Consultation Response from KC, Highways Development Management
2024/91760 Land adj Healey Junior Infants and Nursery School, Healey Lane, Healey, Batley, WF17 8BN
Erection of 19 dwellinghouses with associated car parking, landscaping and boundary treatment and other associated works
Date Responded: 19/12/2024 Responding Officer: CNB Responding Ref: K13-1SE/26

The applicant has submitted Drawing No (557)2405-GWP-00-00-D-A-(PA)-0005 Rev. P17 Proposed Site Plan.

SCALE	PAPER	STATUS
SHOWN	A1	PRELIMINARY
DRAWING NO.		
24106-DCE-XX-XX-D-C-160		
REV.		
P01

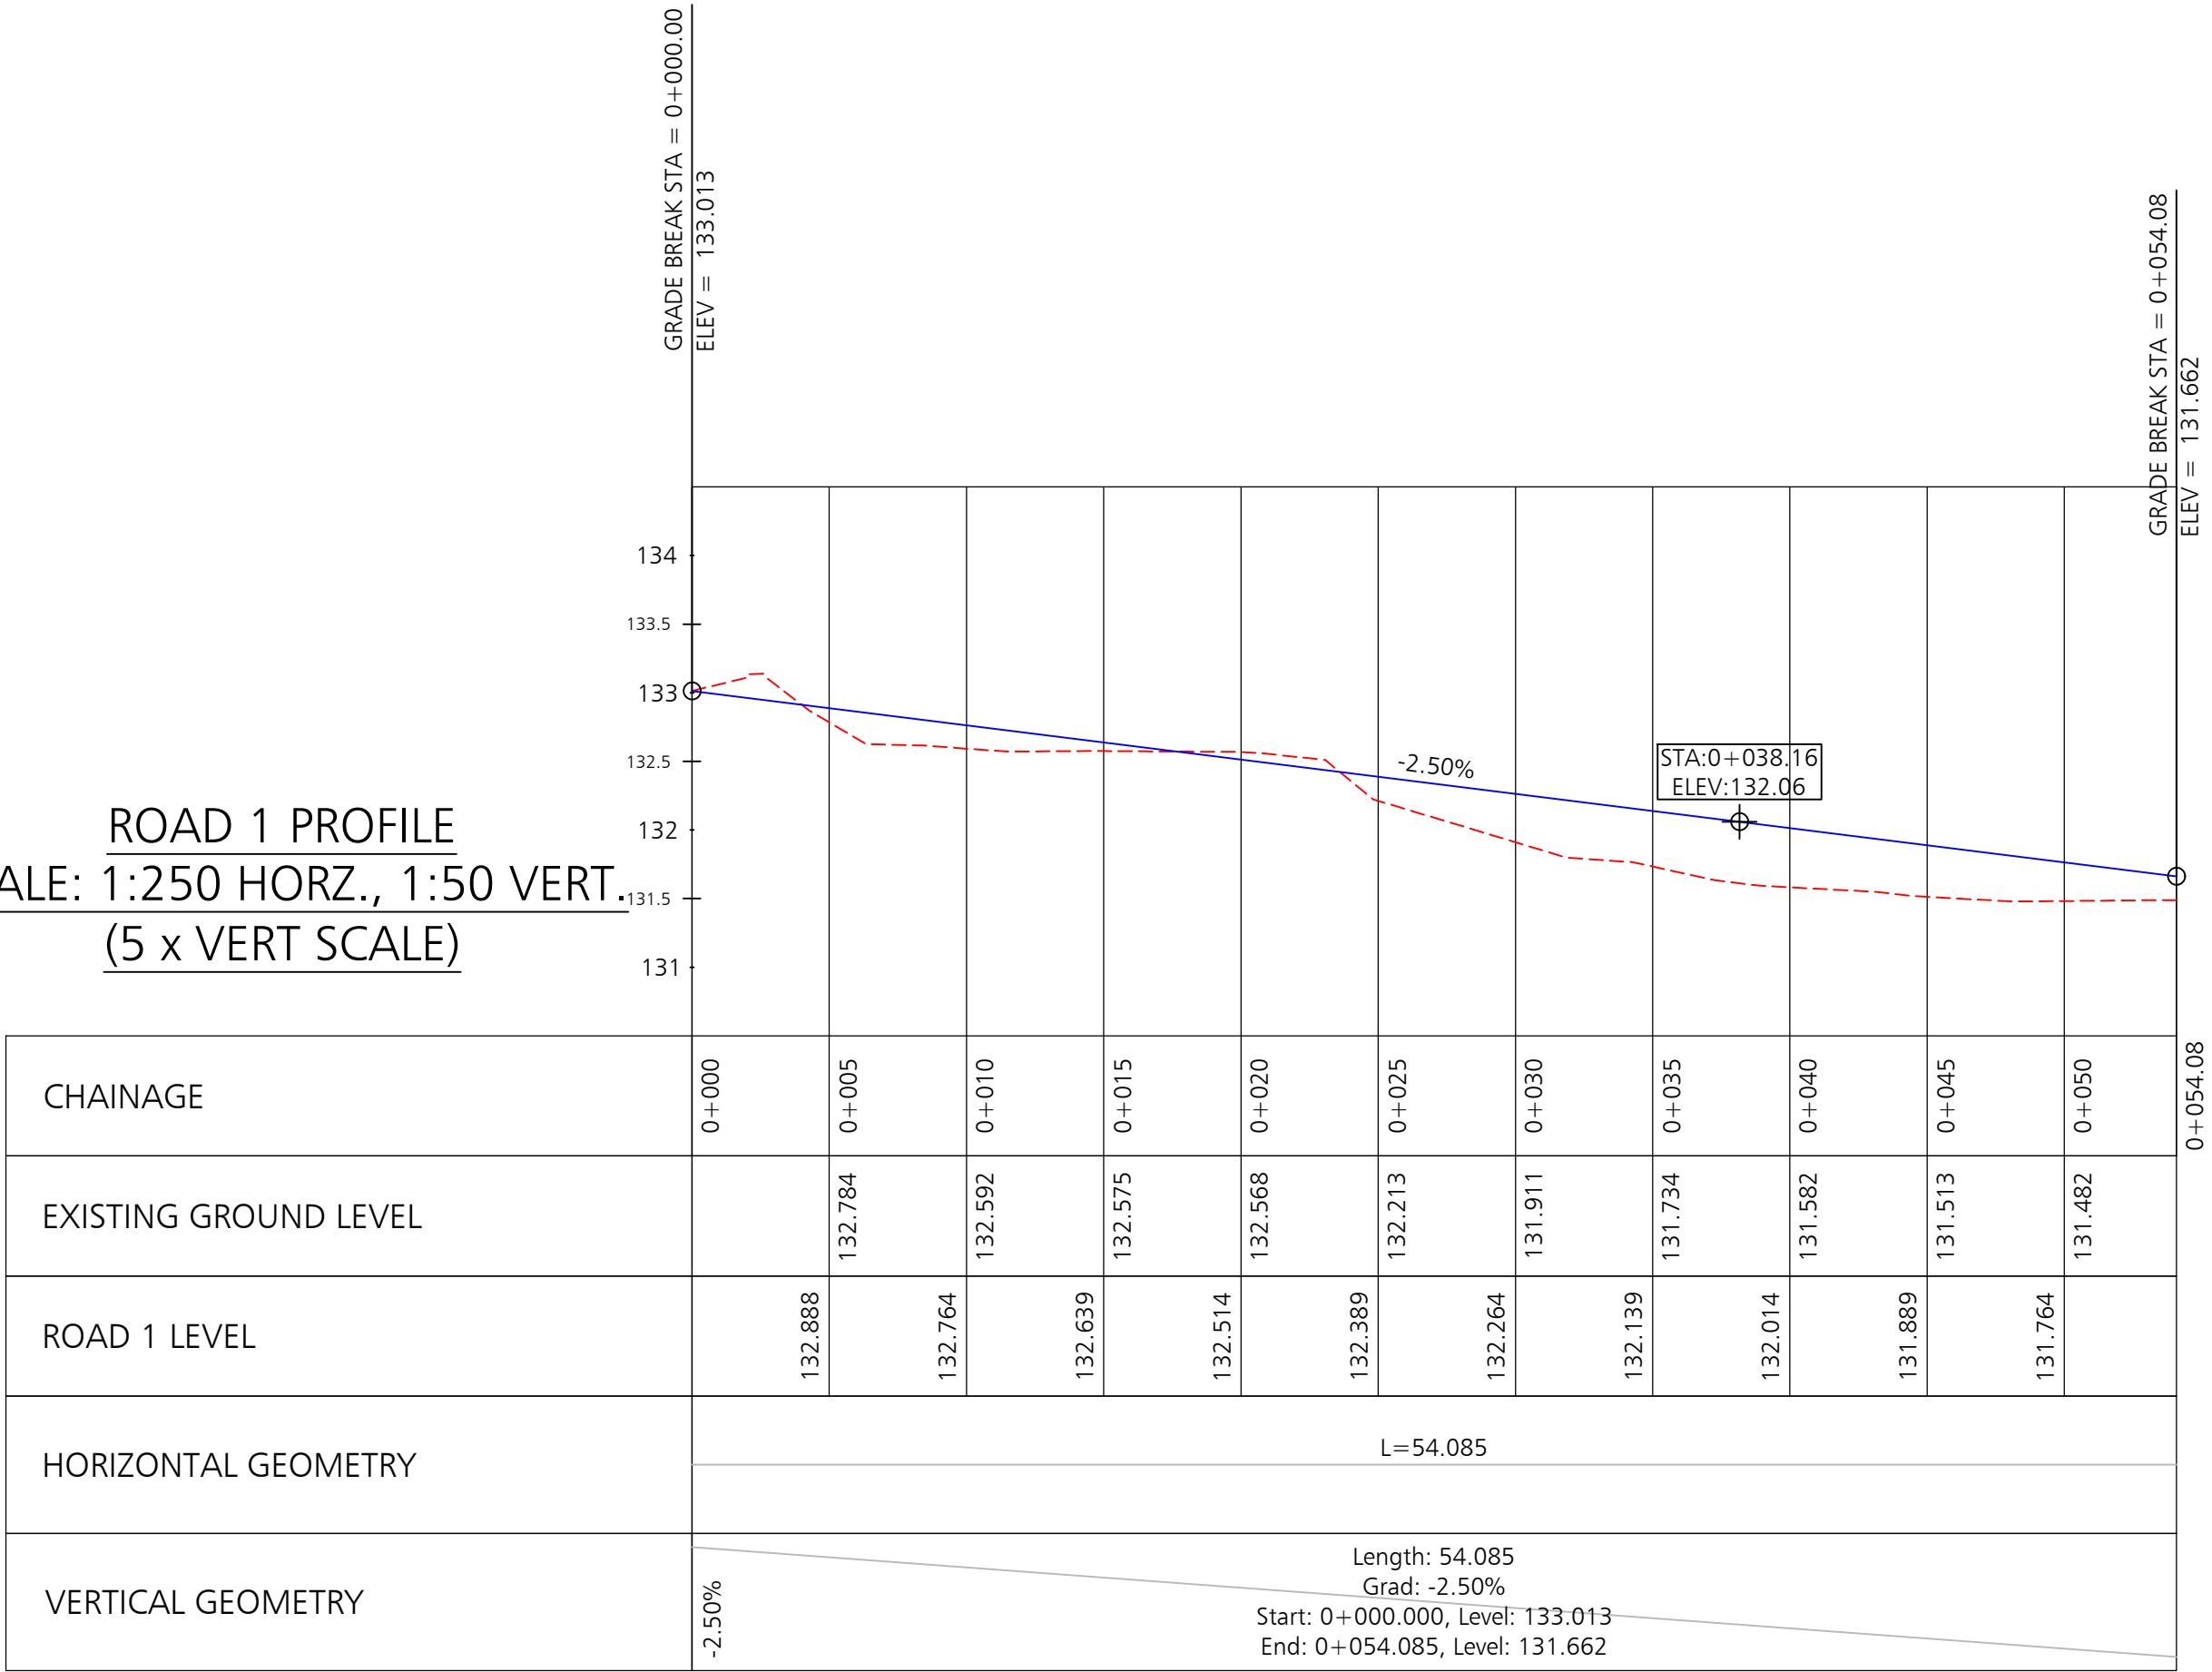
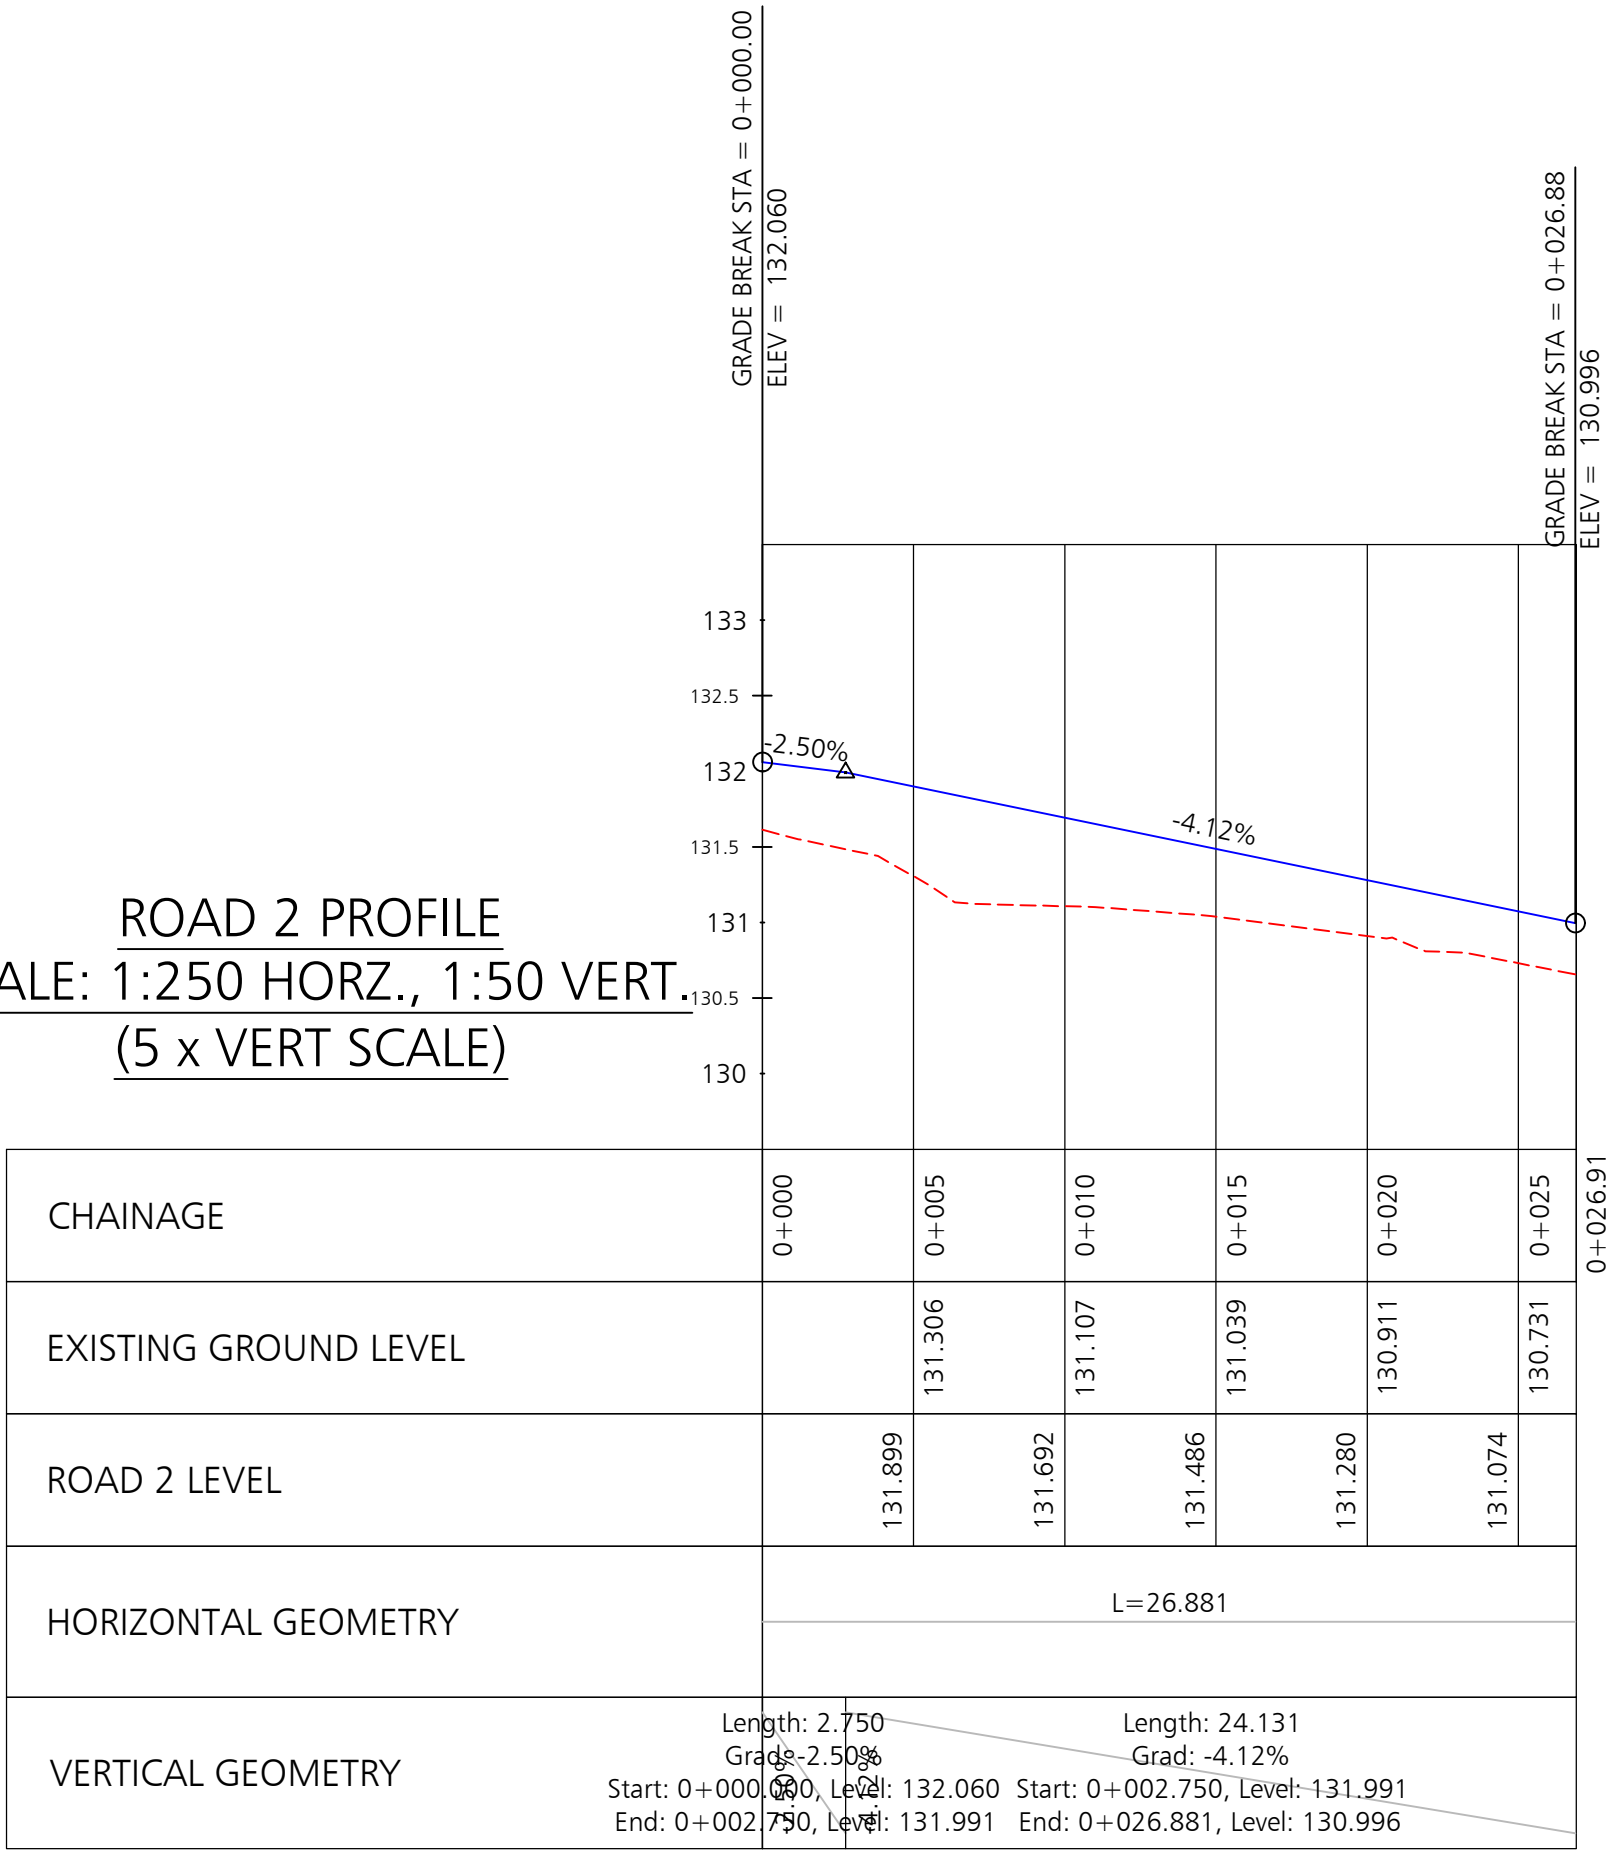
The s38 team have requested that further information will need to be submitted before they would be happy to start the s38 process, this is the provision of a long section drawing (with details of gradient, vertical curves and chainage), The latest version of the layout drawing 0005 Rev. P17 has resolved all their other concerns.

Subject to providing a long section drawing as part of the S38 process, and with the agreement of the Head of Planning, in this instance, given the timescales relating to securing Homes England funding and the need to issue a planning permission, we are prepared to condition the submission of long

sections and Stage 1 RSA. I am satisfied based upon the spot levels on the latest site layout plan, that maximum gradients of no steeper than 1:20 are achievable.

A long section has not been provided and will be required to ensure compliance with the Equalities Act 2010 where necessary. This must include details of the vertical alignment to determine appropriate carriageway and footway gradients. Shared surface carriageways will need to be Equalities Act 2010 (DDA) and Kirklees Design Guide compliant and be no steeper than a maximum of 1:21 or 5%. If the carriageway is steeper than 5% then a Local Residential Street (Type B) with footways both sides would be required as per Table 1.

Prior to commencement of development, the following details associated with the proposed site access and estate streets, as shown on the preliminary site layout plan, ref. (557)2405-GWP-00-00-D-A-(PA)-0005 Rev. P17 Proposed Site Plan, shall be submitted to and approved in writing by the Local Planning Authority. The details shall include:

- Long Sections showing the vertical alignment of all estate streets;
- Stage 1 Road Safety Audit (RSA) based on an Approved RSA Brief, Designers Responses and Agreed RSA Actions, covering all aspects of these works.
